# CITY OF MERCER ISLAND

## REVISION/DEFERRED SUBMITTAL FORM

GELOTTE HOMMAS DRIVDAHL  
ARCHITECTURE

Re: Itemized Revisions for Permit 1706-084

A0.1

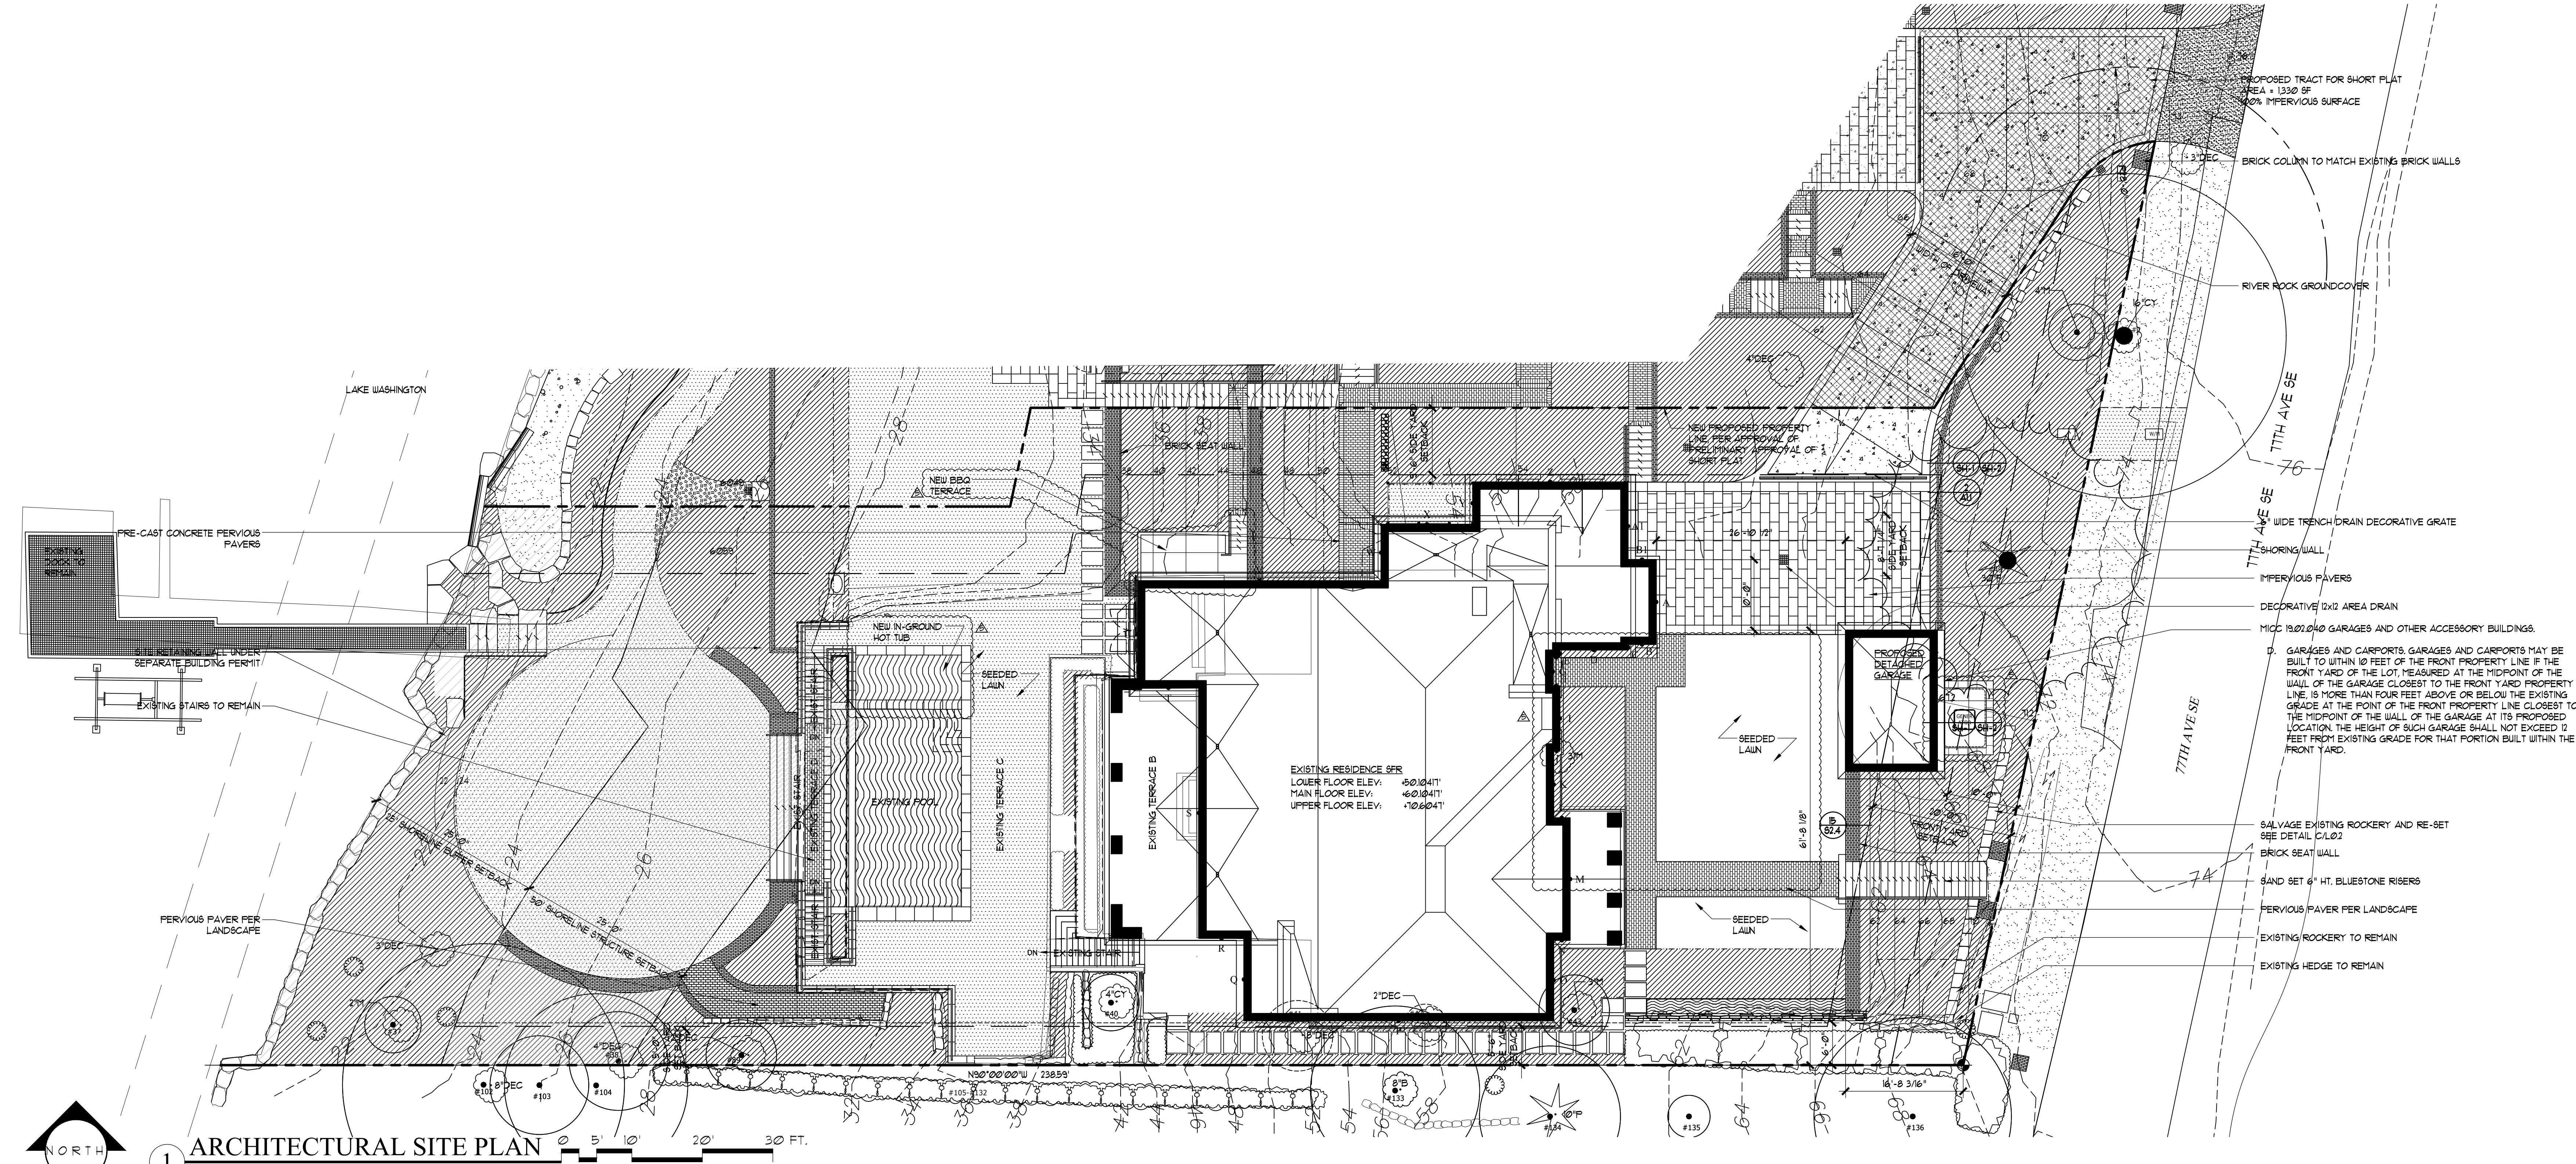
Sheet A0.1: Added Landscape Plan sheets  
Sheet A0.1: Revised lot coverage calculations  
Sheet A1.1: Revised Impervious Surface Coverage  
Sheet A1.1: Revised Gross Floor Calculations  
Sheet A1.1: Revised Front Lawn  
Sheet A1.1: Added Backup Generator pad  
Sheet A1.1: Revised Hot Tub  
Sheet A1.1: Added BBQ terrace with steps to grade

A2.1D

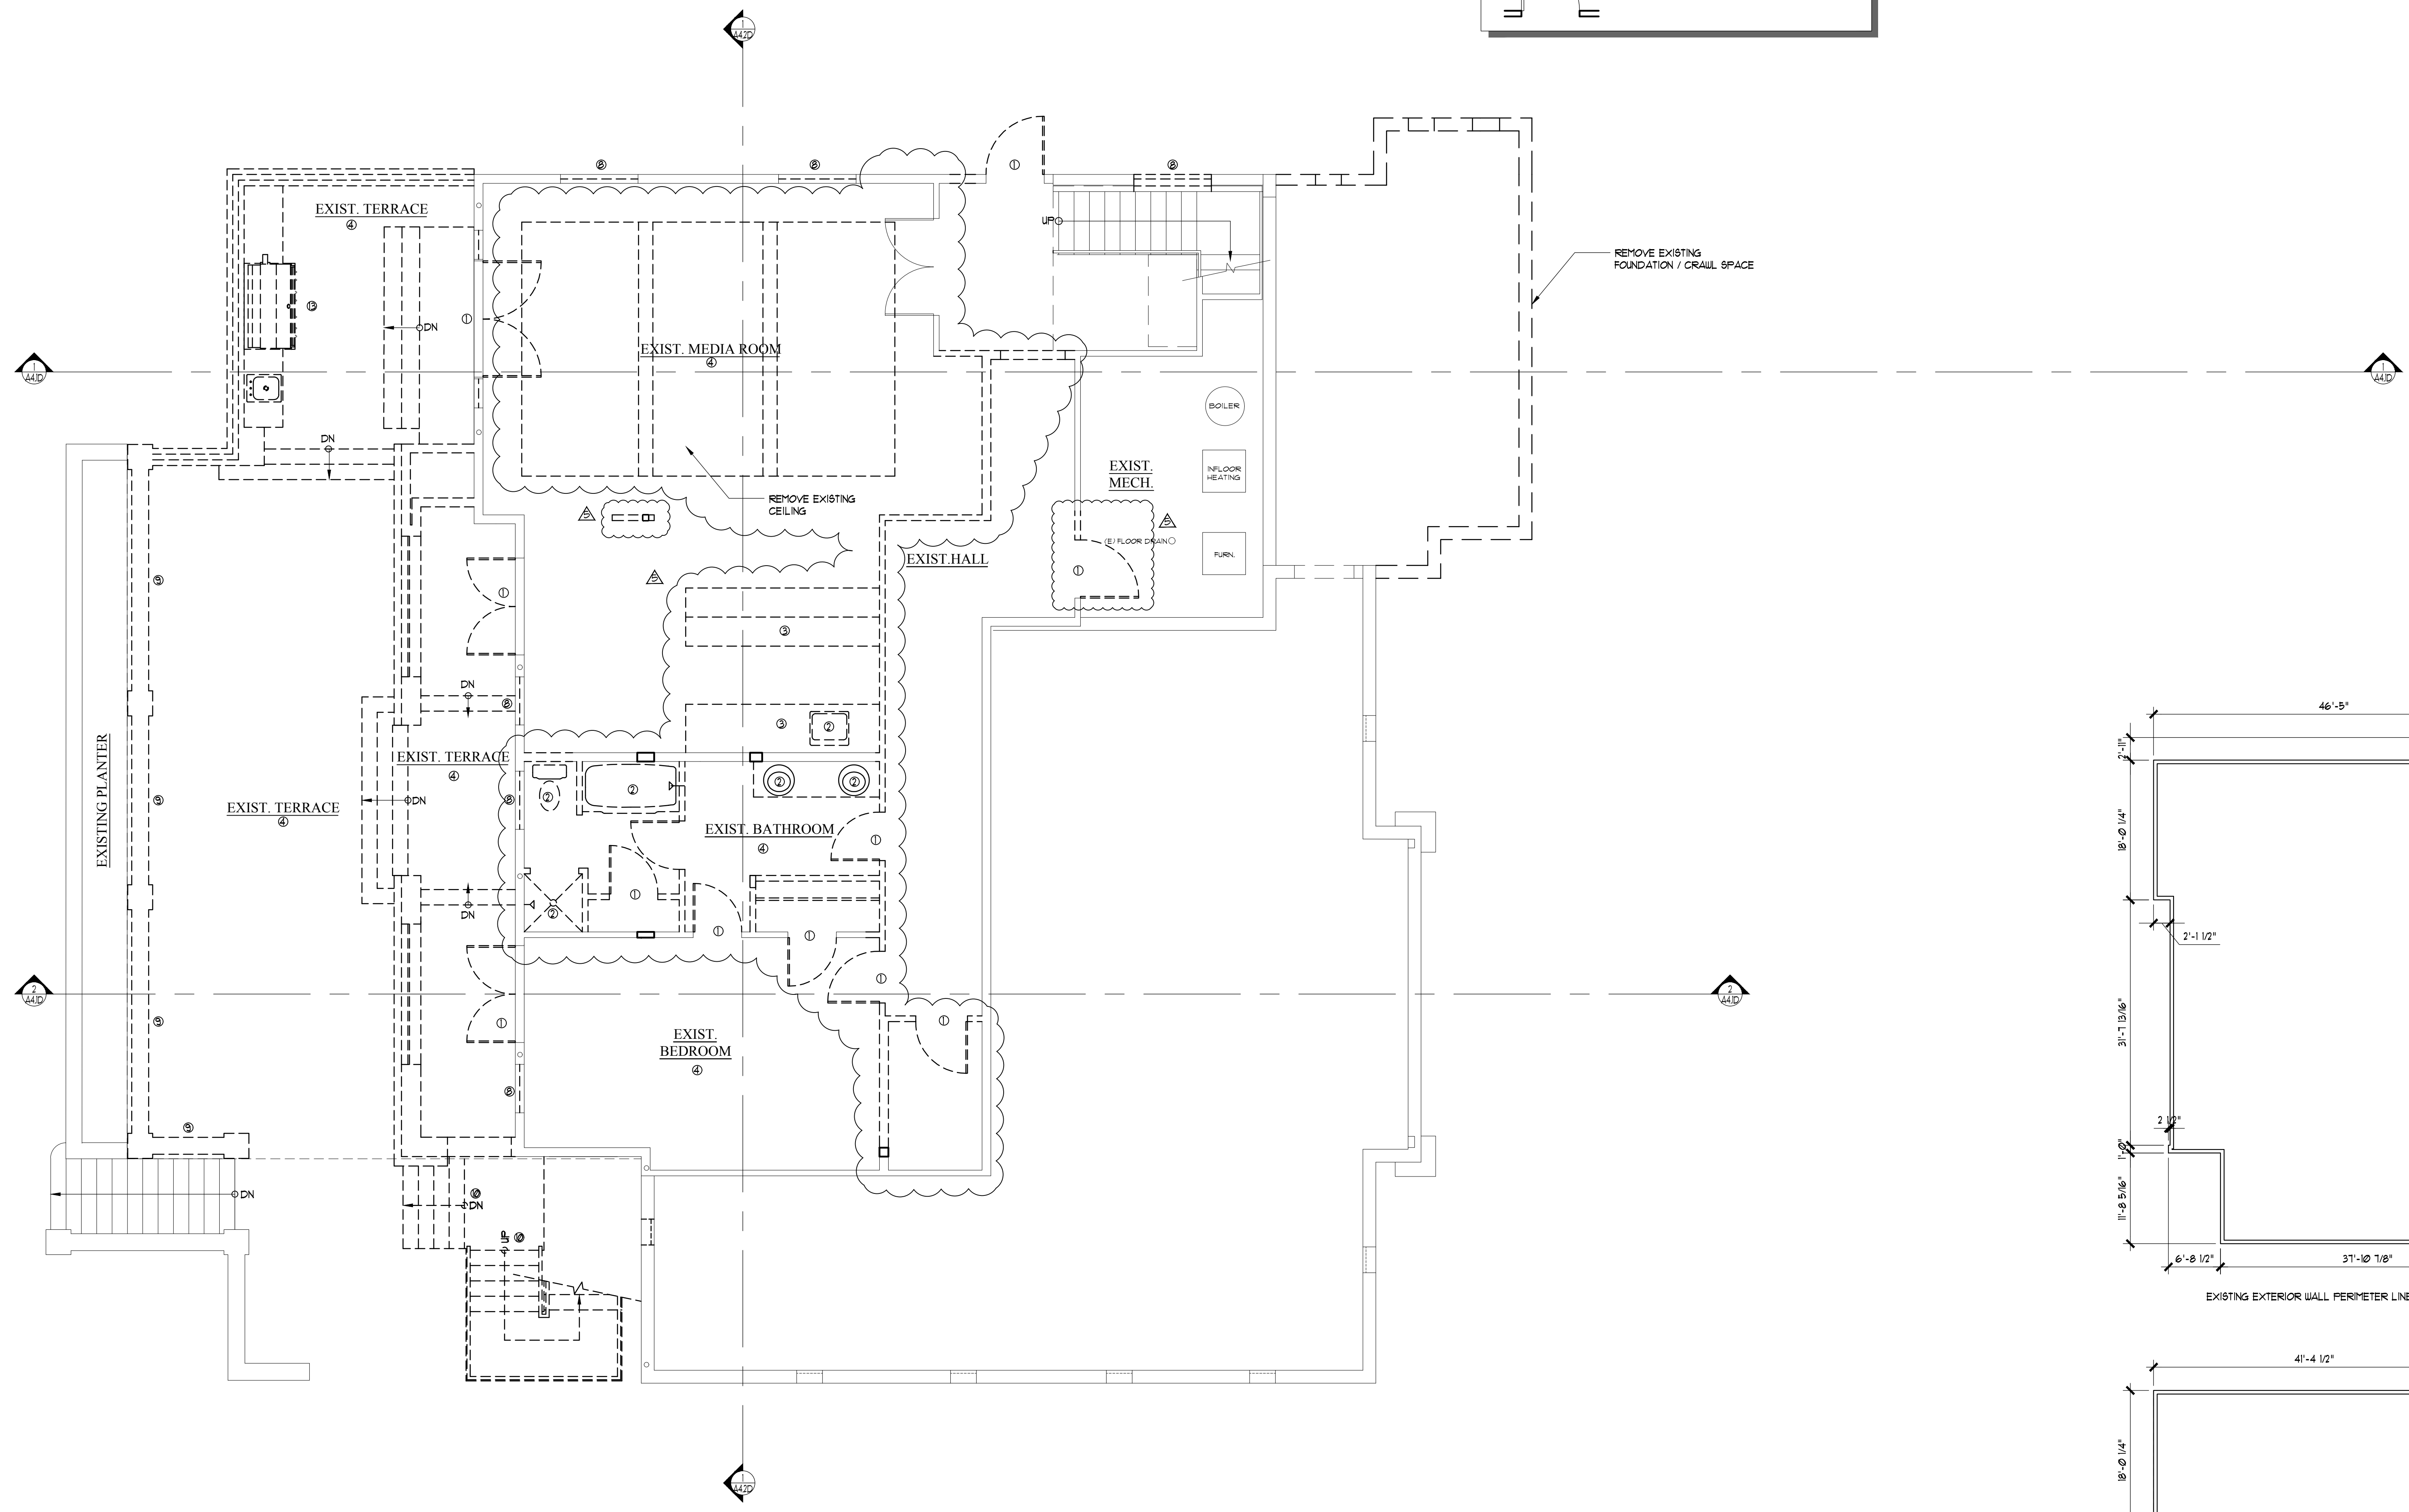
Sheet A2.1D: Reconfiguration of demolished walls at Lower Floor  
Sheet A2.2D: Reconfiguration of demolished walls at Main Floor  
Sheet A2.3D: Reconfiguration of demolished walls at Upper Floor  
Sheet A3.1D: Revised Exterior Demolition scope and notes  
Sheet A3.2D: Revised Exterior Demolition scope and notes  
Sheet A3.3D: Revised Exterior Demolition scope and notes  
Sheet A4.1D: Revised Building Section Demolition scope and notes  
Sheet A4.2D: Revised Building Section Demolition scope and notes

PROPOSED LOWER FLOOR PLAN

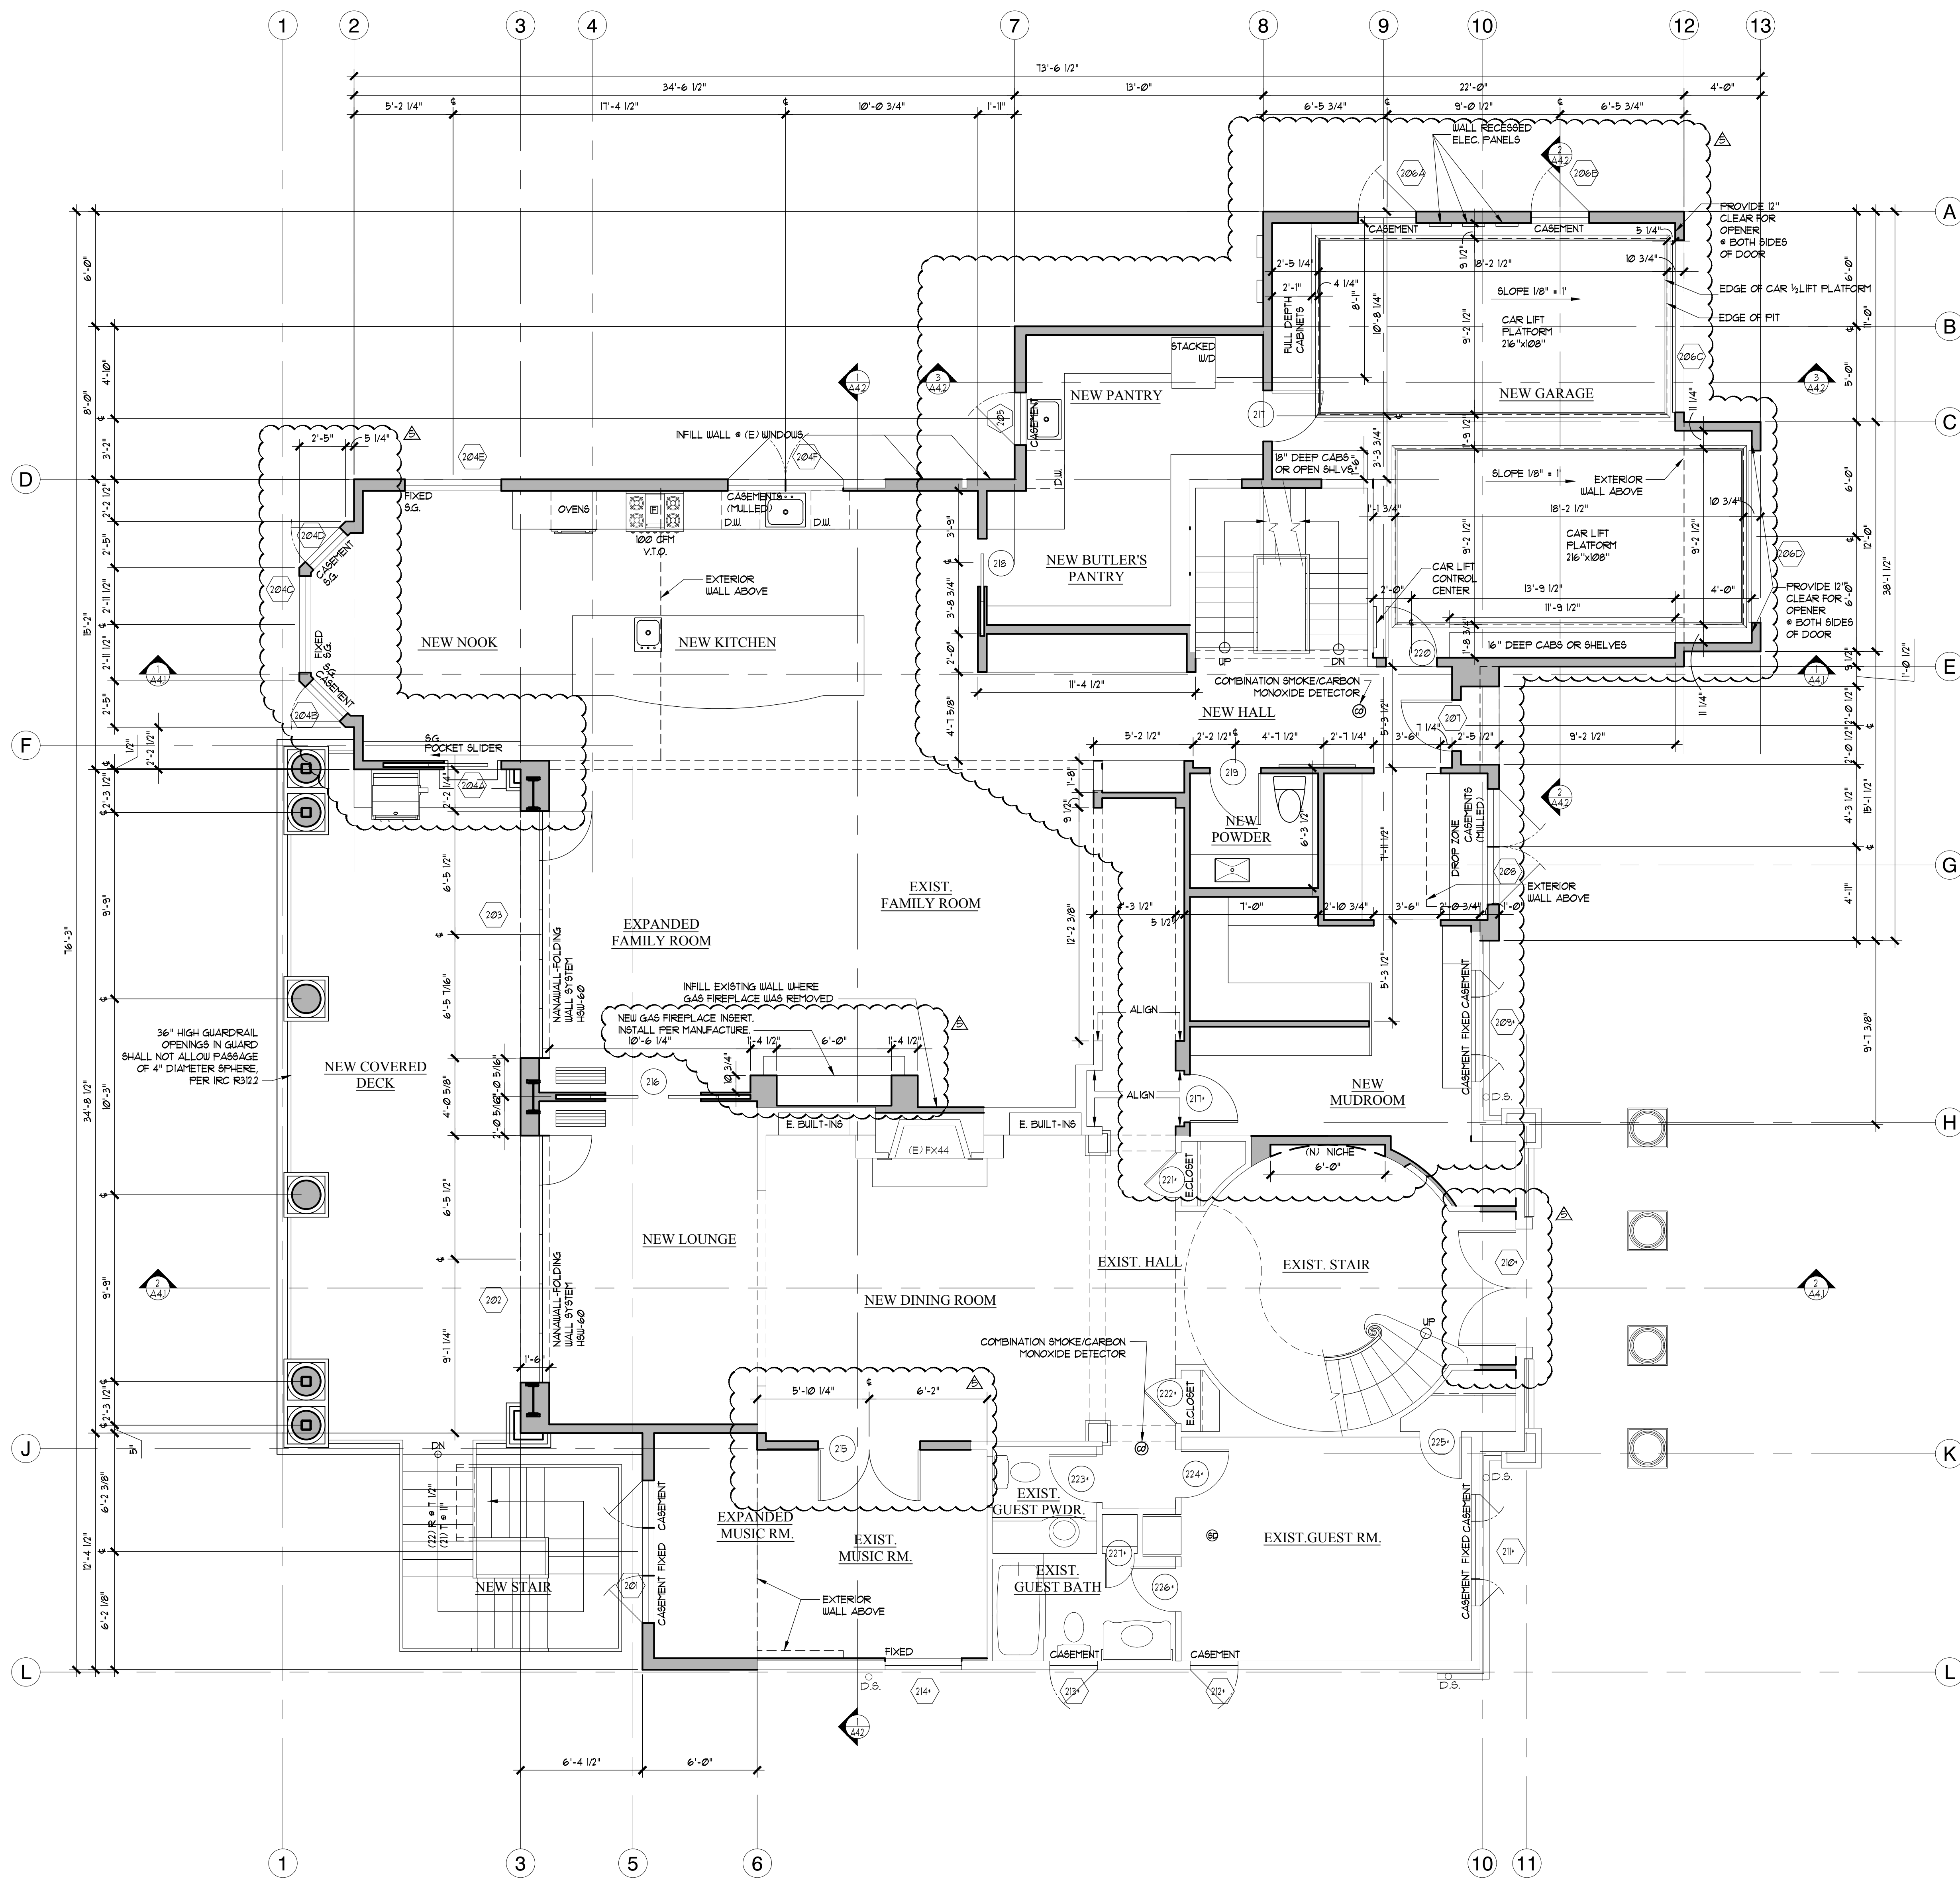
Sheet A2.1: Reconfigured & added to Northwest terrace, added stairs to grade.  
Sheet A2.1: Reconfigured northeast stair hall  
Sheet A2.1: Reconfigured south bedroom/bathroom.

Sheet A2.1: Revised foundation under garage to include car lift pit(s)  
Sheet A2.1: Added BBQ terrace with steps to grade.  
Sheet A2.2: Added Bay window unit and exterior door to Northeast Nook adjacent Kitchen.
